Your ref: SSD 9667
File no MC-18-00004

SSD 9667 - Light Horse Interchange Business Hub, Eastern Creek

Blacktown Council's submission to SSD 9667 - Light Horse Interchange Business Hub, Eastern Creek

Drawing Name: **Landscape Plan**
PRELIMINARY
Scale: 1:500 @ A1
Job Number: **SS18-3892**
Drawing Number: **103**
Issue: **G**

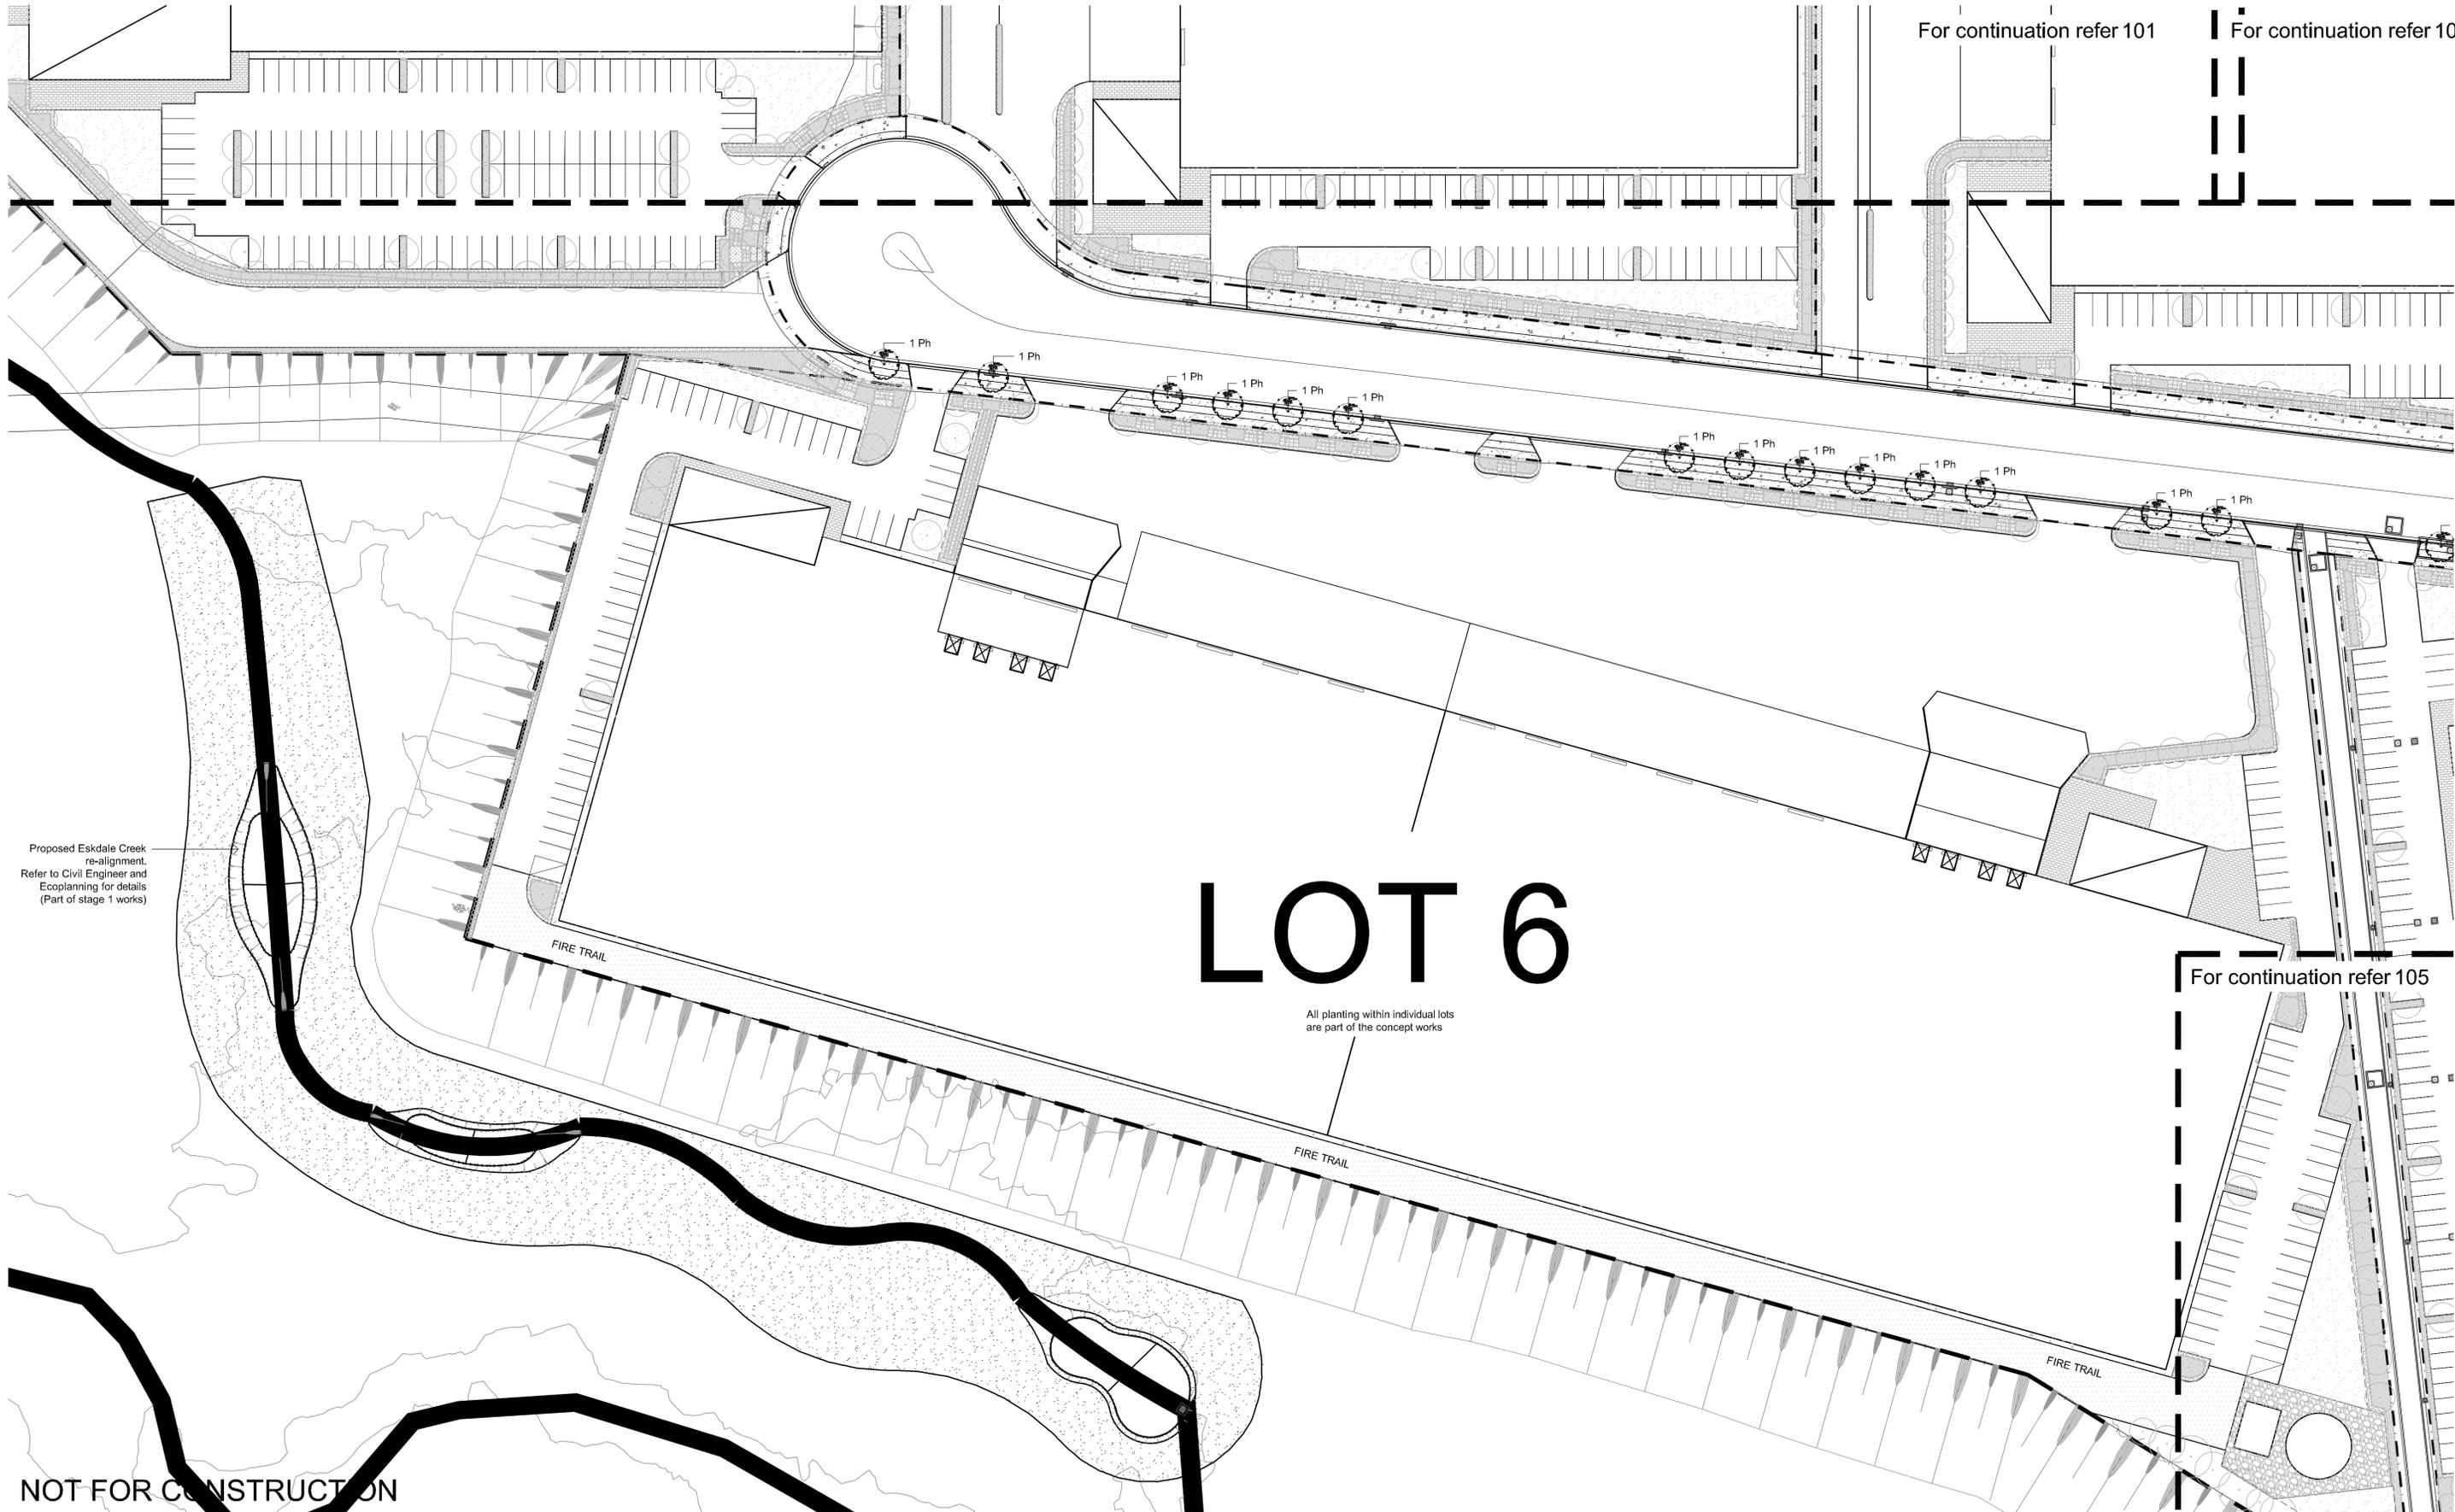
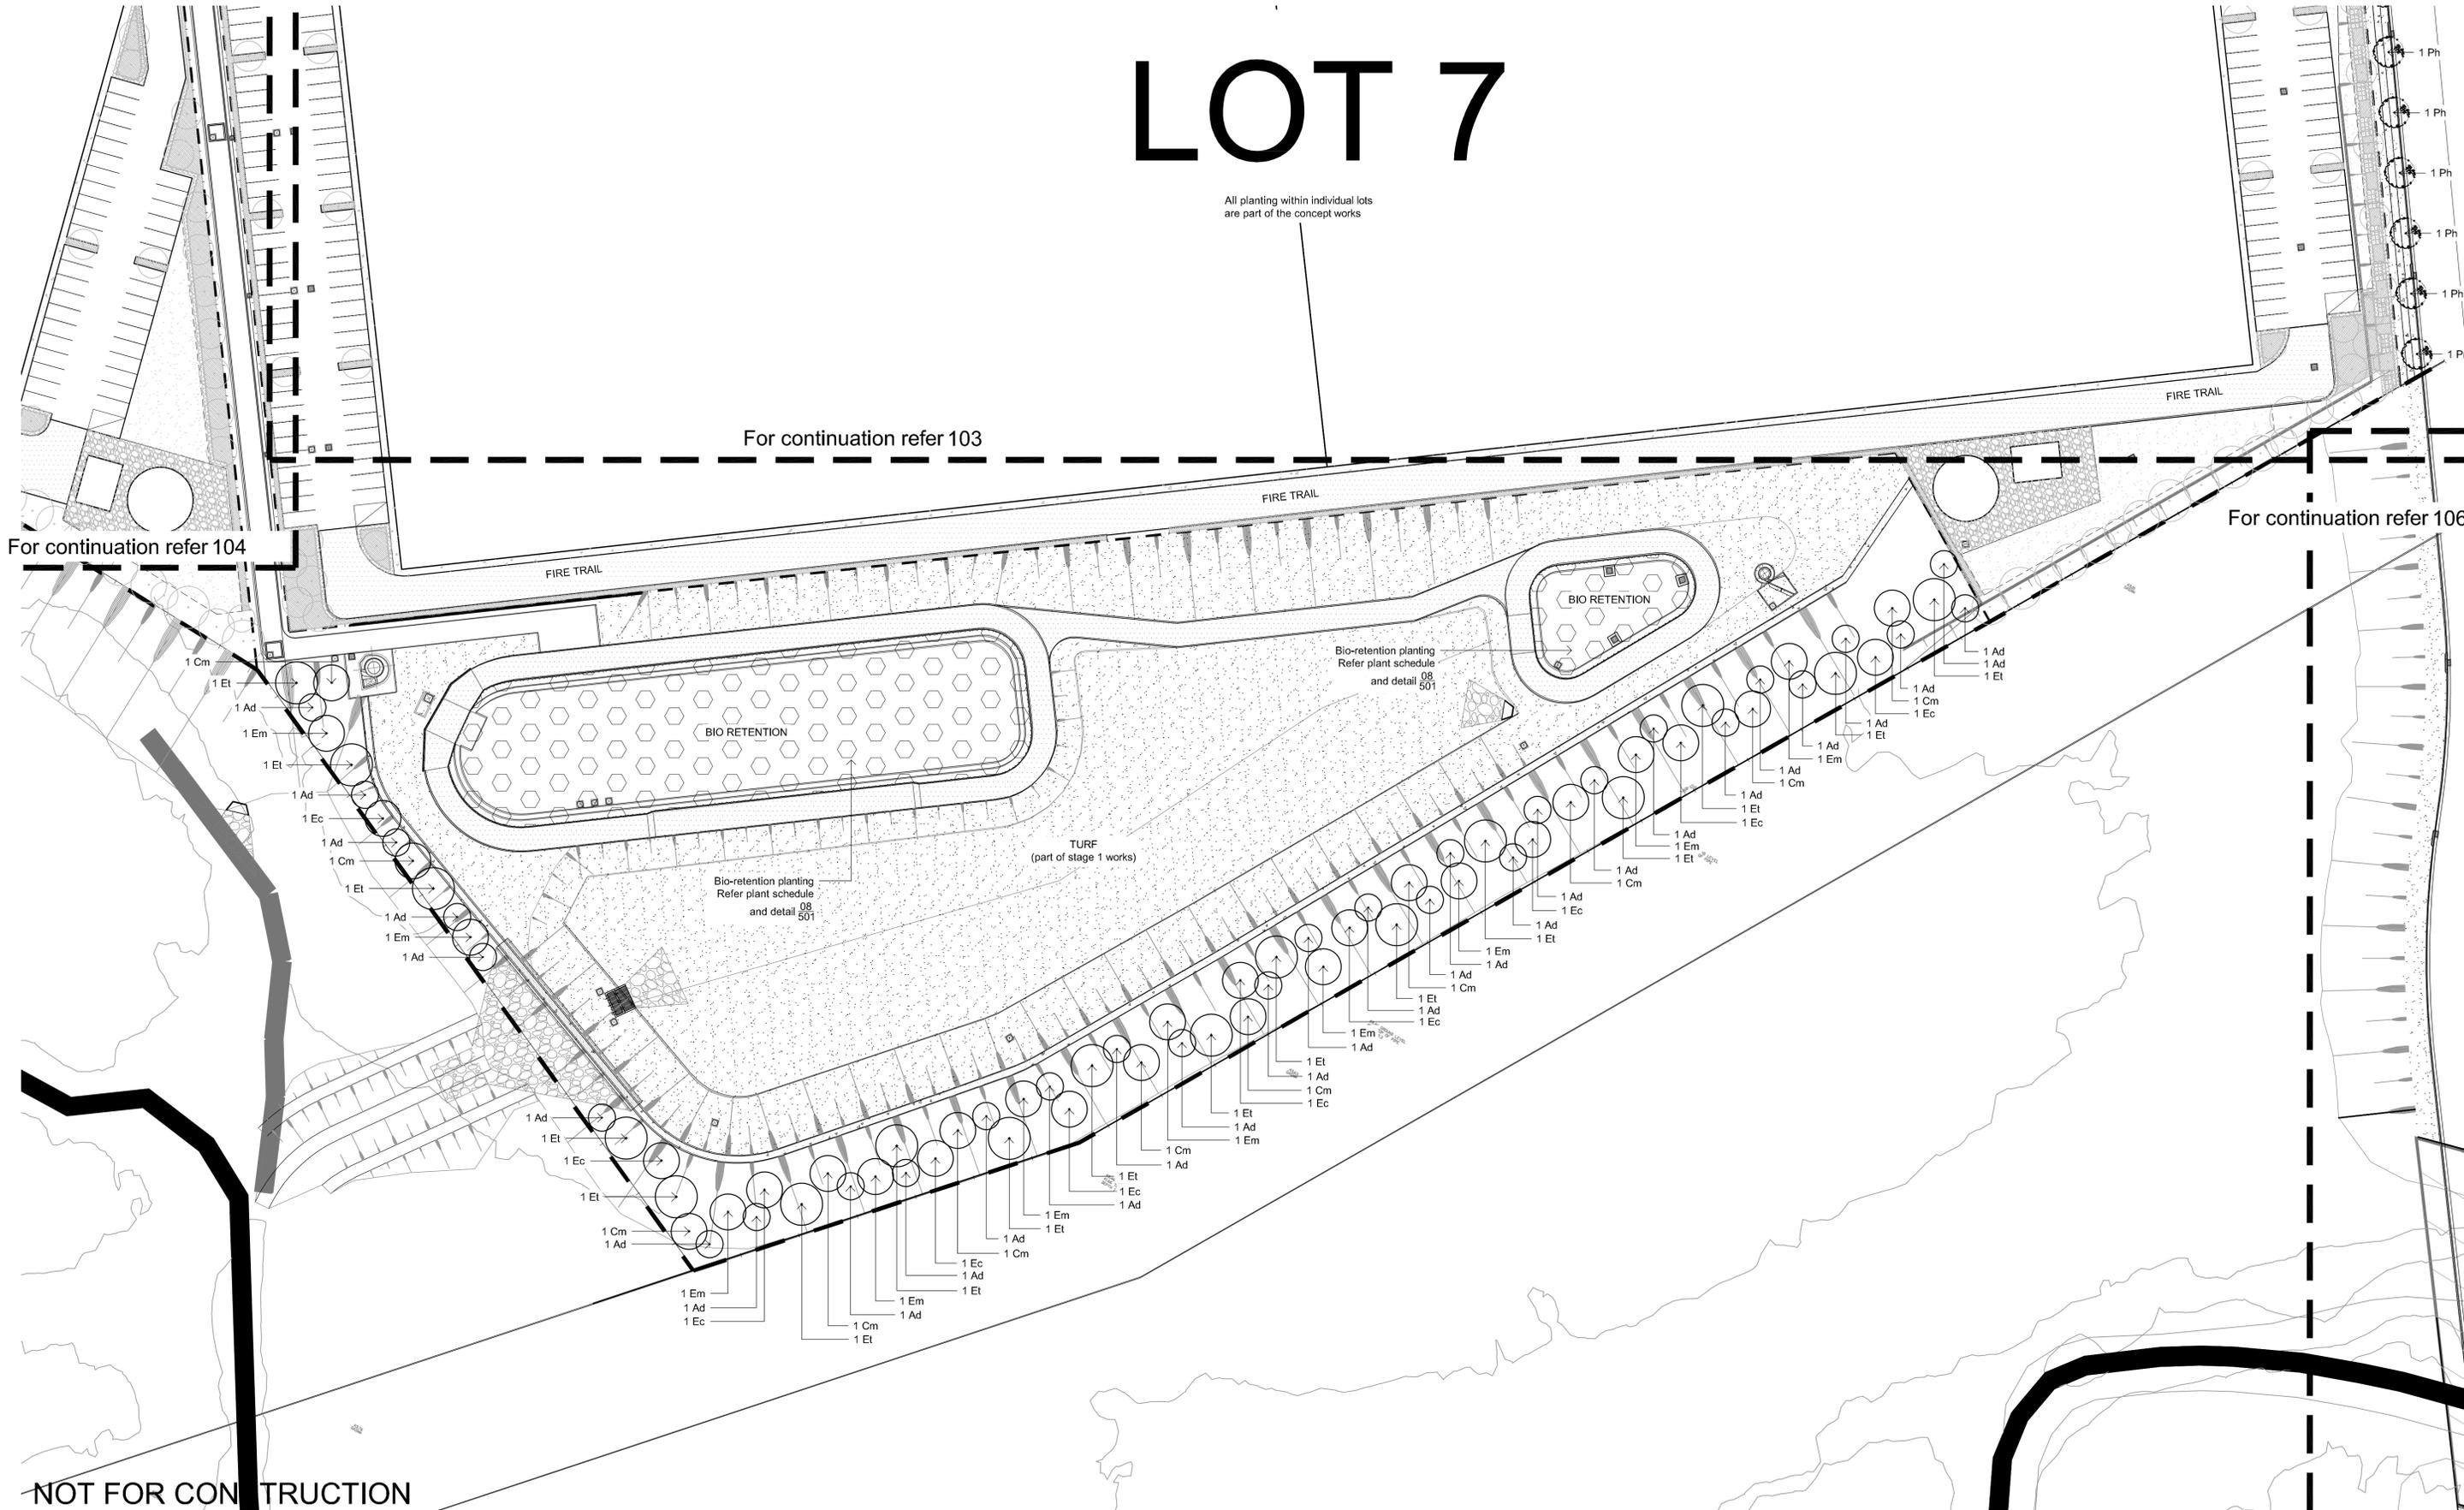
- 5. Provide a revised landscape plan by Site Image Job number SS18-3892 dated 24/1/2020 to extend the landscape works for the vegetated riparian corridor to a minimum average of 20 m outside the creek banks of the relocated Eskdale Creek up to and including the confluence with Reedy Creek. Where 20 m cannot be achieved on one side, it is to be compensated on the other side of the creek. The vegetation is to be generally in accordance with the Biodiversity Development Assessment Report (BDAR) – prepared by Eco Planning 2019.
